Our reference: ECM Ref: 9878076
Contact: Kathryn Saunders
Telephone: (02) 4732 8567

3 February 2022

Response to Request for Advice - Kemps Creek Estate - SSD-9522-MOD3 at No. 657 Mamre Road, Kemps Creek

TUNRING PATHS PLAN-RIGHT TURN
SCALE 1:300

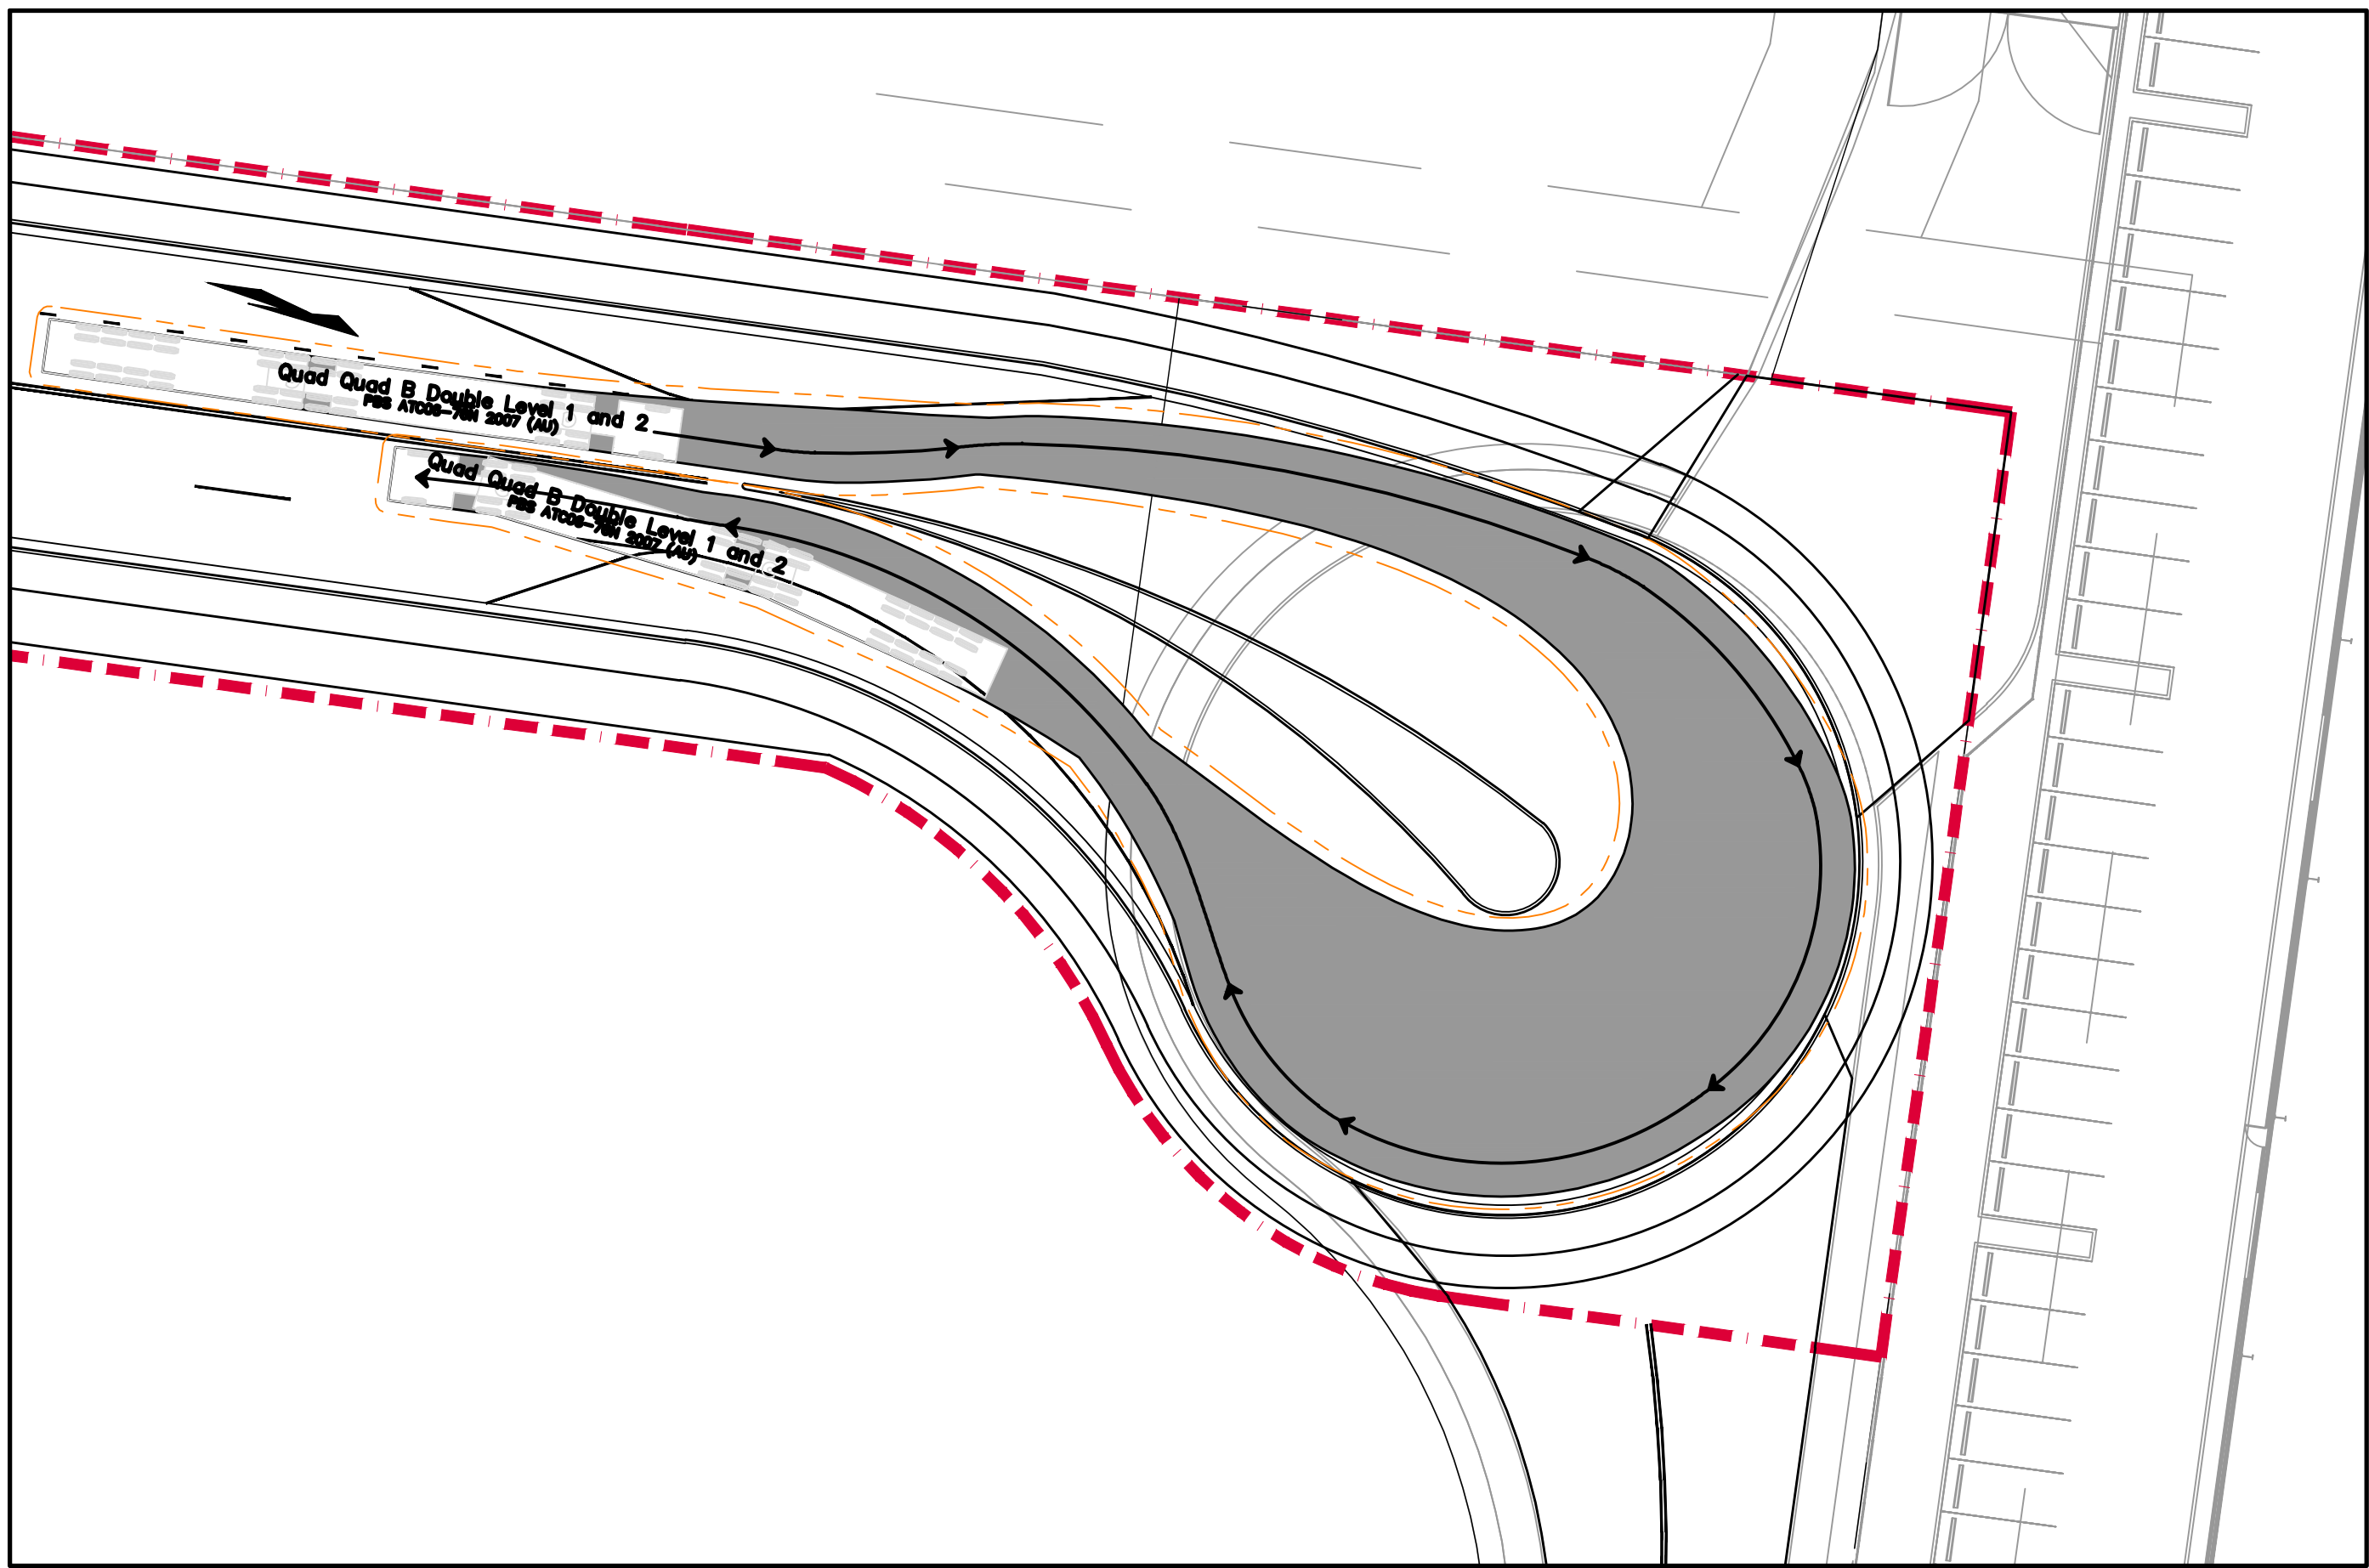
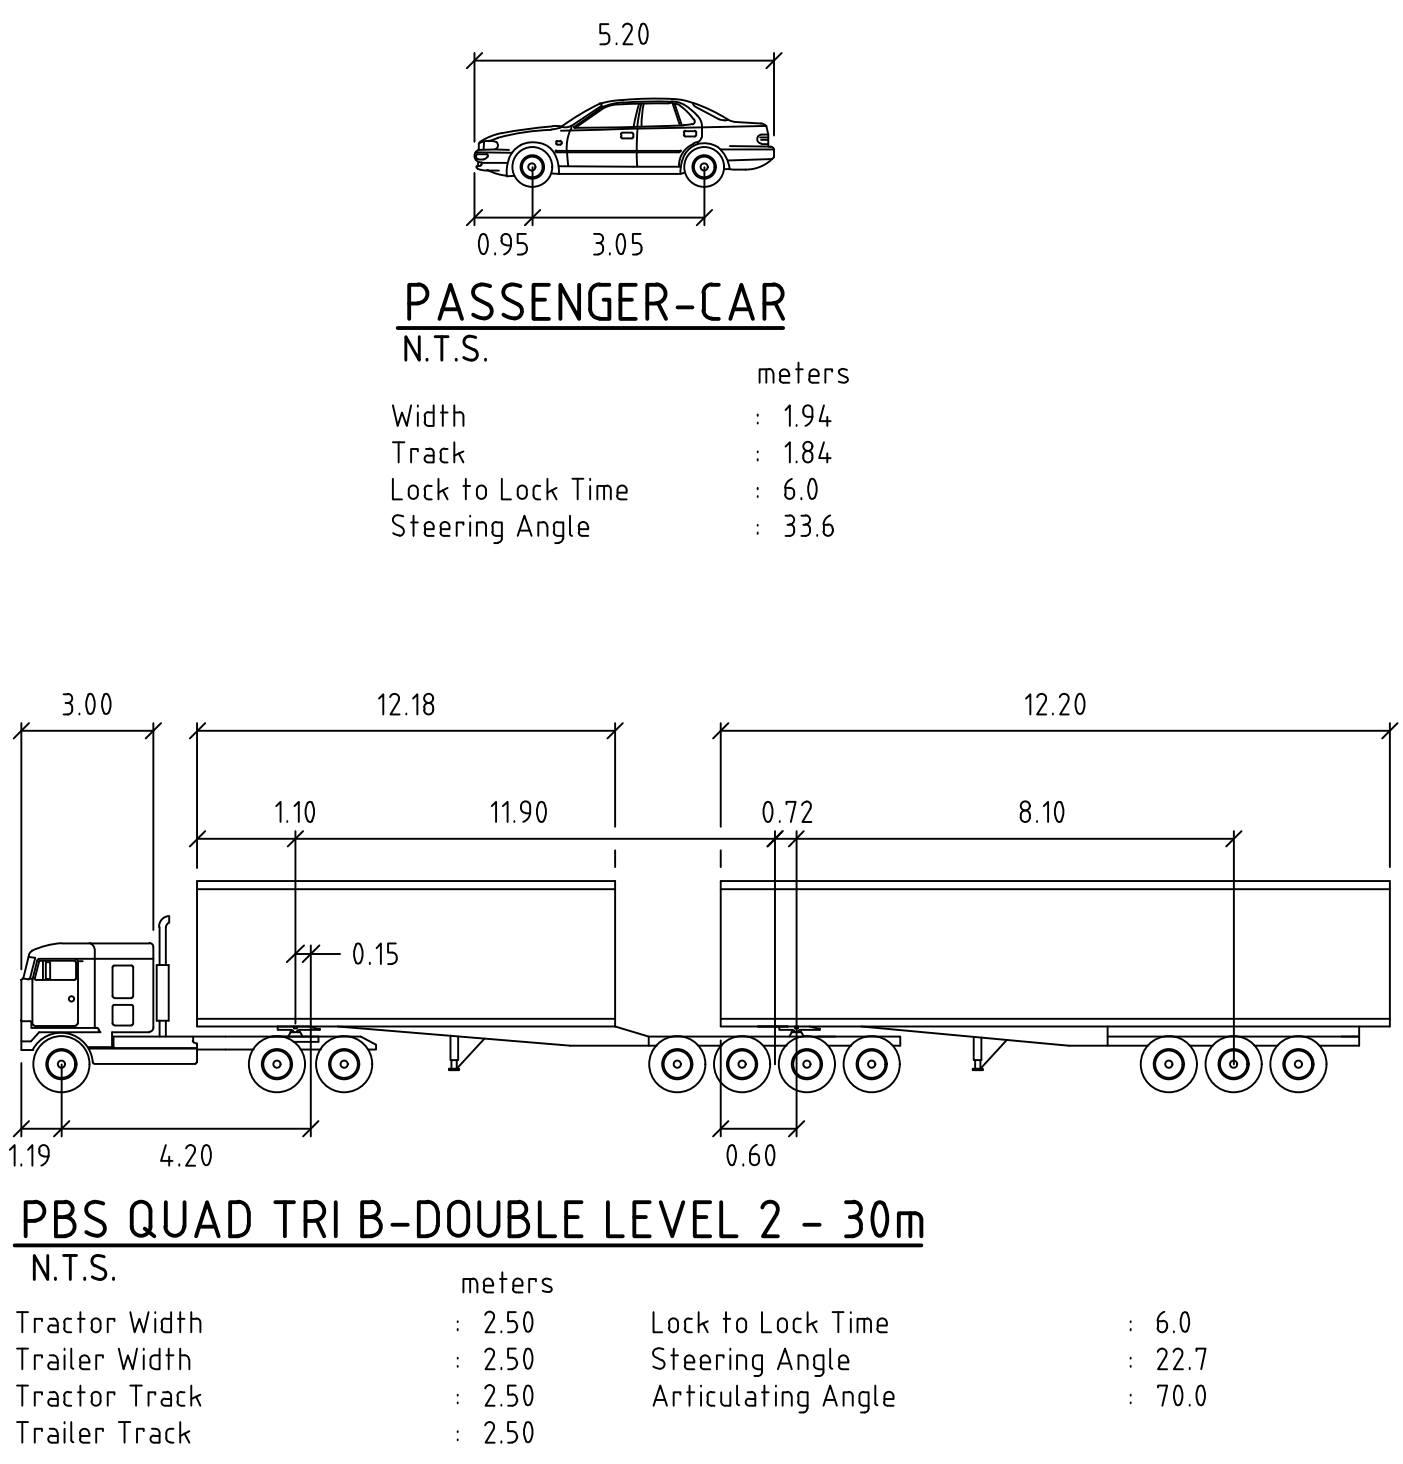
It is raised for the Department's consideration that the plans by Costin Roe Consulting, drawing numbers Co13362.02-SK4-06, SK4-07, SK4-08 & SK4-09 have not demonstrated that the future intersection and road network has been tested for a 36.5m PBS Level 3 Type A vehicle.
